Our ref: HA/2022/124004/05-L01
Your ref: M/16/22/PL
Date: 20 December 2022

FURTHER MODELLING INFORMATION: RE-CONSULTATION - LAYING OUT OF AN 18 HOLE 72 PAR GOLF COURSE, A 9 HOLE GOLF COURSE, PRACTICE GREENS AND A DRIVING RANGE INCLUDING A BUGGY COMPOUND; THE FORMATION OF A NEW ACCESS ONTO THE A259; CONSTRUCTION OF A CLUB HOUSE WITH ASSOCIATED GOLF CLUB FACILITIES; THE CONSTRUCTION OF A MAINTENANCE BUILDING AND EXTERNAL AREA OF HARDSTANDING; THE LAYING OF PARKING, NEW ROADS AND PATHS; NEW LANDSCAPE PLANTING; SURFACE WATER DRAINAGE BASINS AND WATER STORAGE RESEVOIRS; AND OTHER EARTH WORKS AND INFRASTRUCTURE. THIS APPLICATION ALSO LIES WITHIN THE PARISHES OF CLIMPING AND YAPTON, IS A DEPARTURE FROM THE DEVELOPMENT PLAN AND AFFECTS A PUBLIC RIGHT OF WAY. THIS APPLICATION IS SUBJECT TO AN ENVIRONMENTAL STATEMENT. LAND SOUTH OF GREVATTS LANE/A259 CLIMPING.

HYDRAULIC MODEL RESULTS

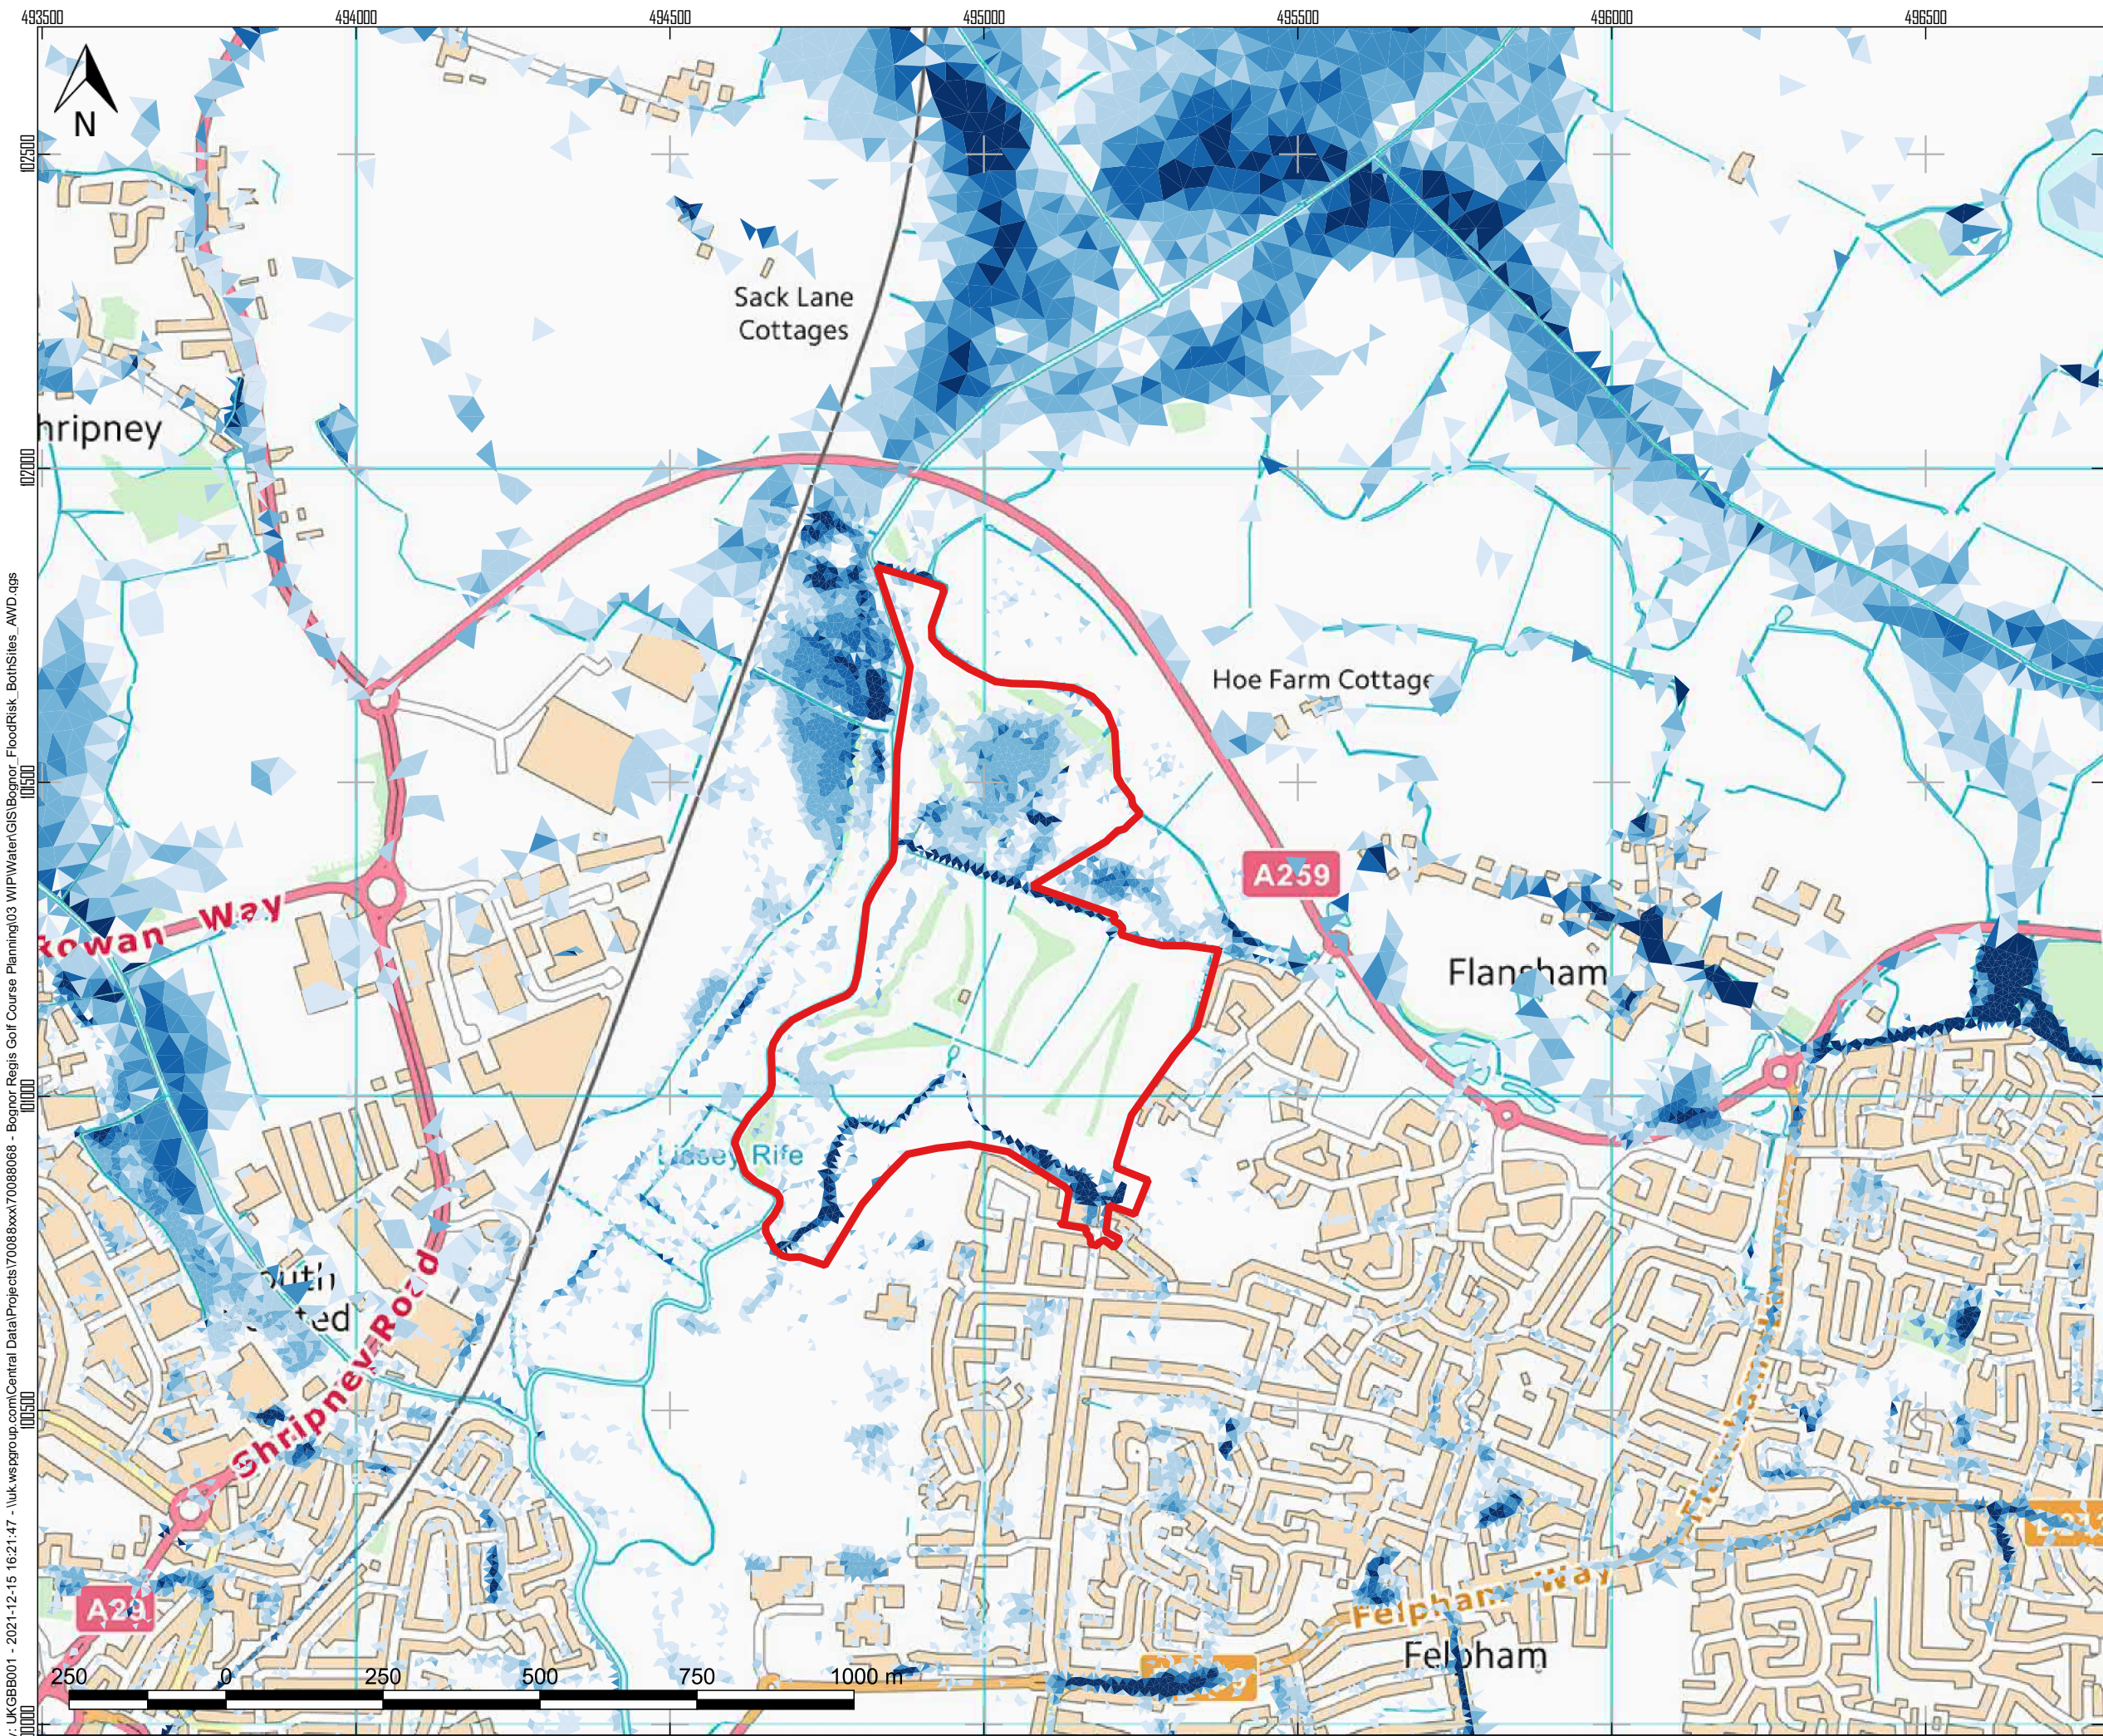
The mapped outputs shown in the supplied Technical Note dated 24/11/2022 are clipped to the development site boundary. This means no values have been provided for Grevatts Lane or the adjacent floodplain.

Please provide flood level difference maps that show the impact on flood levels for the adjacent floodplain including; Grevatts Lane, levels north of Grevatt Lane and south surrounding the development site on all sides.

To overcome our objection, the Applicant should submit an further information which demonstrates that the development will not increasing flood risk elsewhere. Where possible, it should reduce flood risk overall.
